**From:** Lorimer, Elliott <Elliott.Lorimer@lancashire.gov.uk>  
**Sent:** 16 August 2019 14:31  
**To:** planning  
**Subject:** Application Ref: 3/2019/0690  
**Attachments:** Undulating Lowland Farmland E.pdf

Please find below my response (on behalf of the Forest of Bowland AONB Partnership) regarding the planning application 3/2019/0690.

Proposed Site Layout

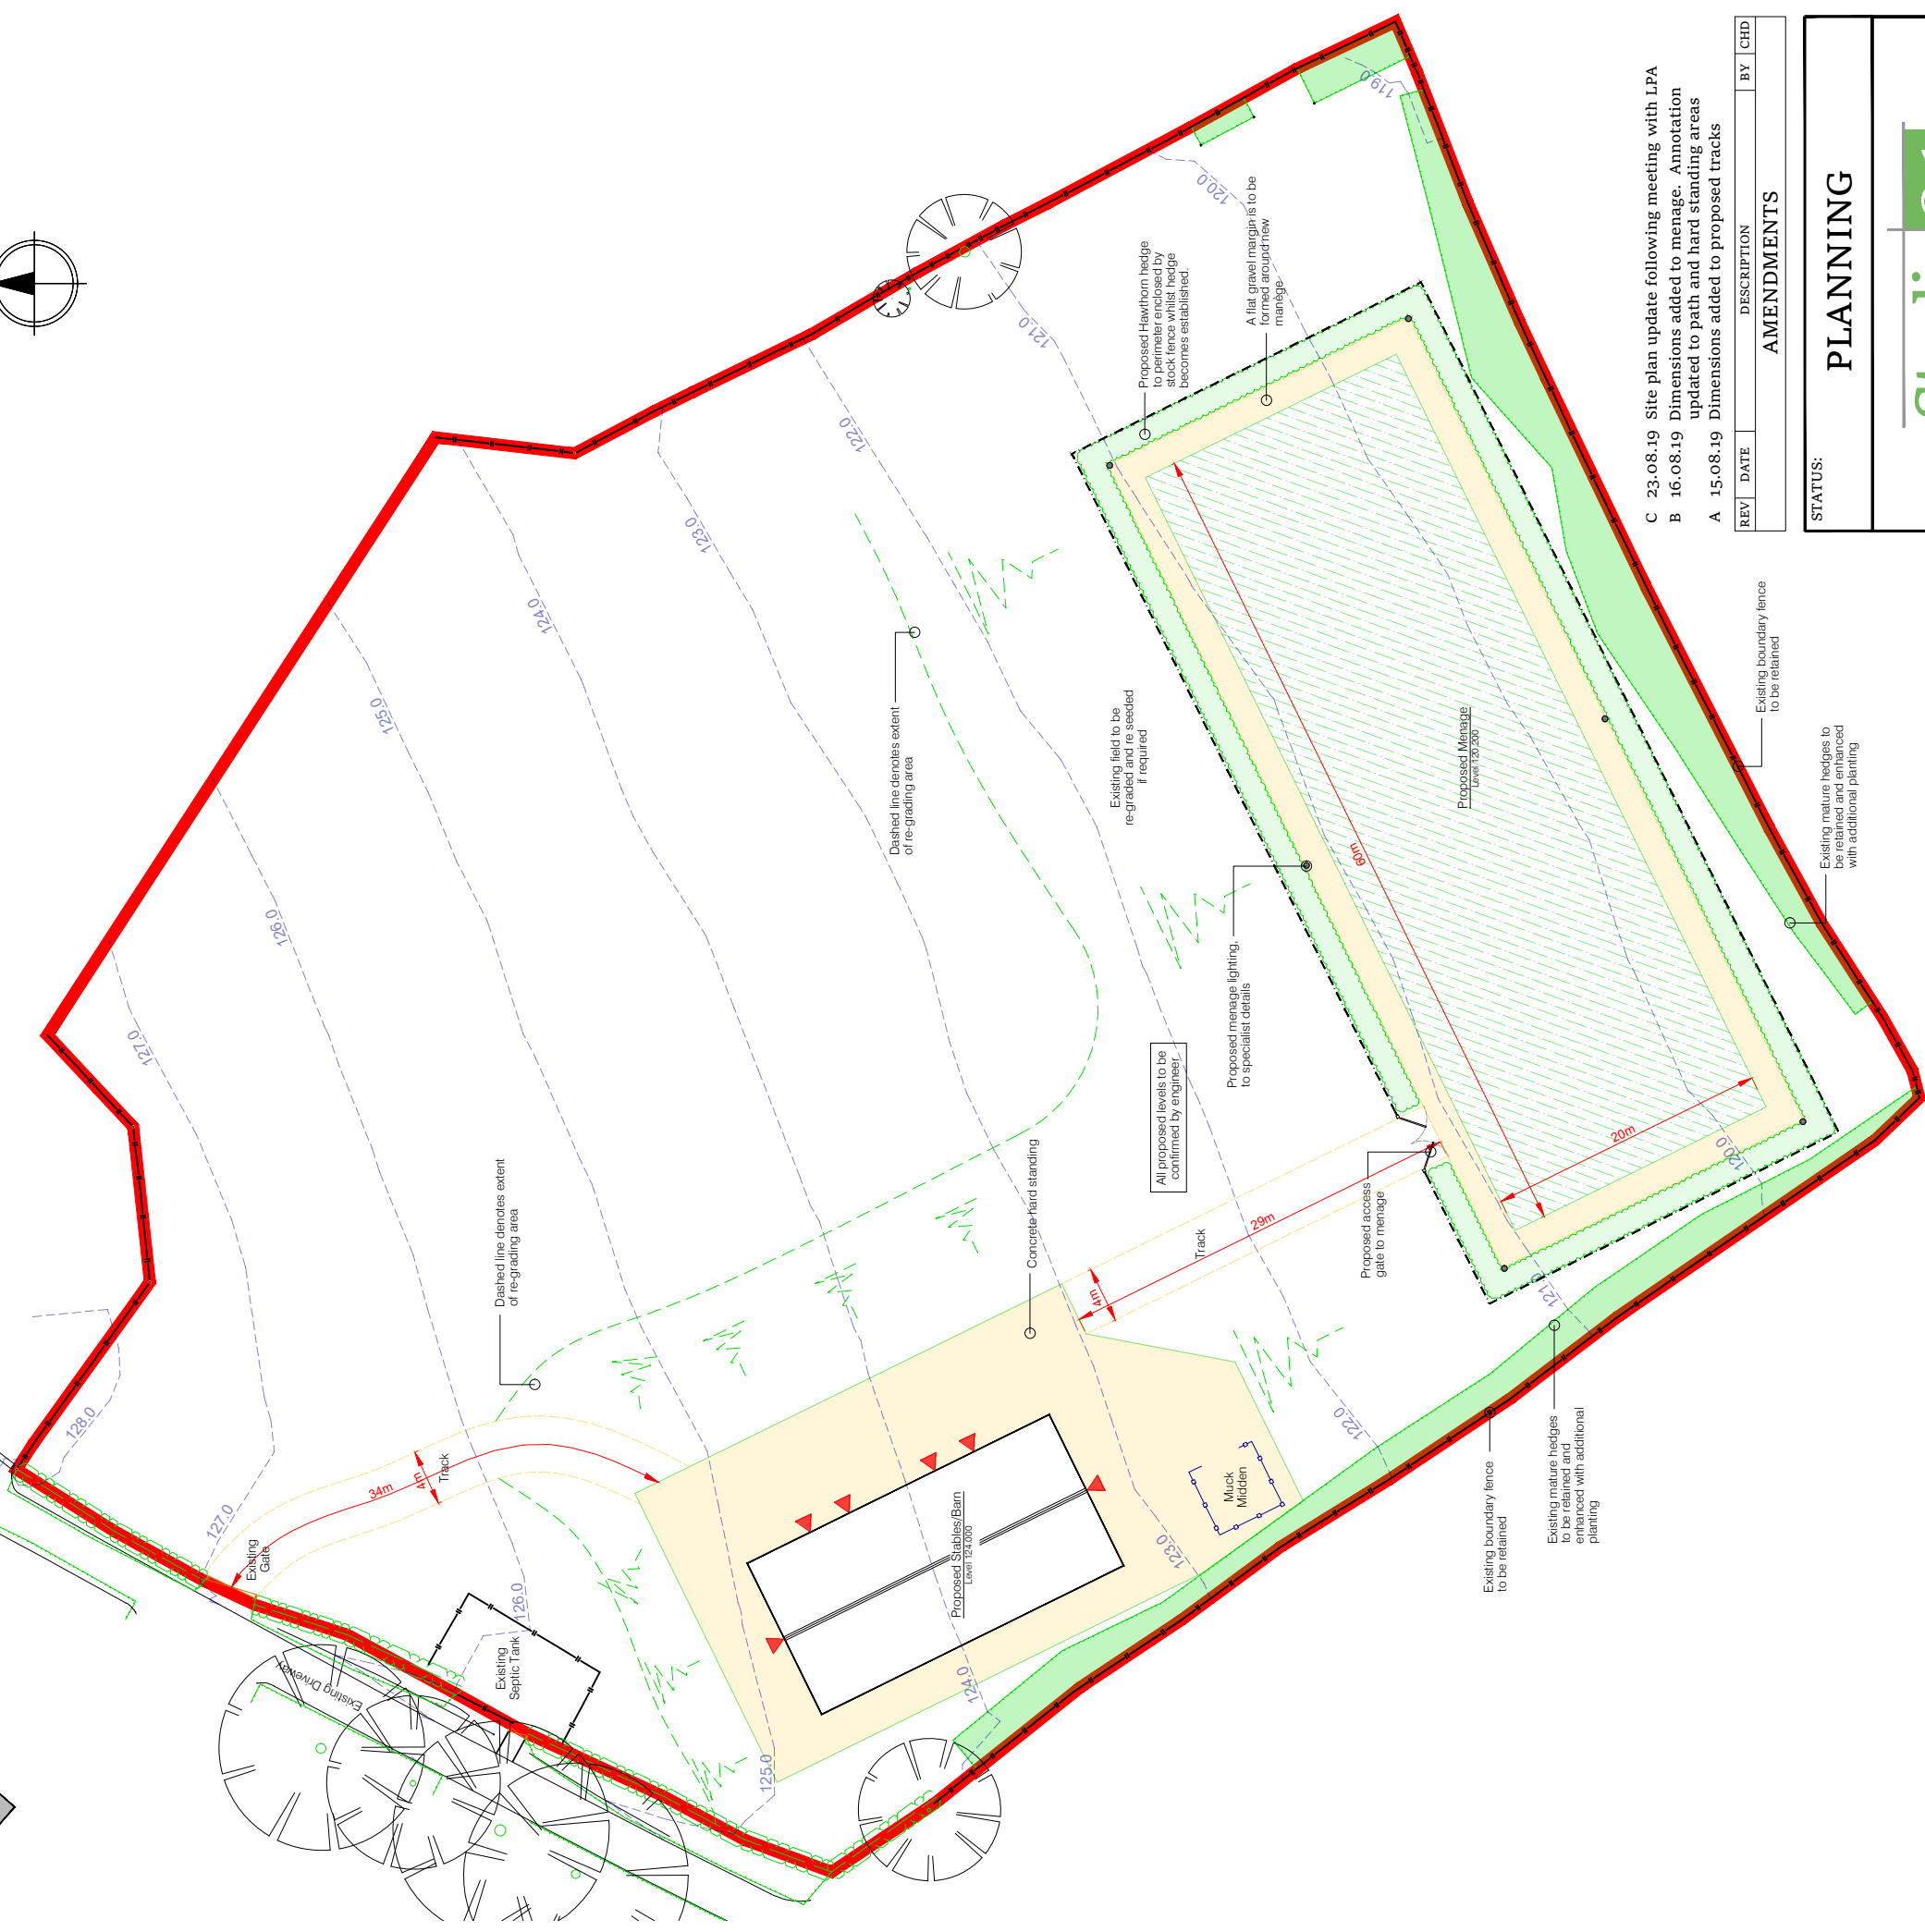
The proposal outlines that the manège will be 'illuminated by six pole mounted LED lighting units, each of approximately 100 LUX' with limited hours. The AONB Partnership has produced a [position statement](#) on lighting to help protect dark skies within the area. The AONB Partnership requests that the Council requires the applicant to use lighting systems/arrangements to minimise glare and spill.

In addition, the proposal outlines plans to enhance and creation new hedgerows. To help further mitigate the landscape and visual effects of the proposal, the AONB Partnership recommends the inclusion of hedgerows trees within any enhanced or new hedgerows.
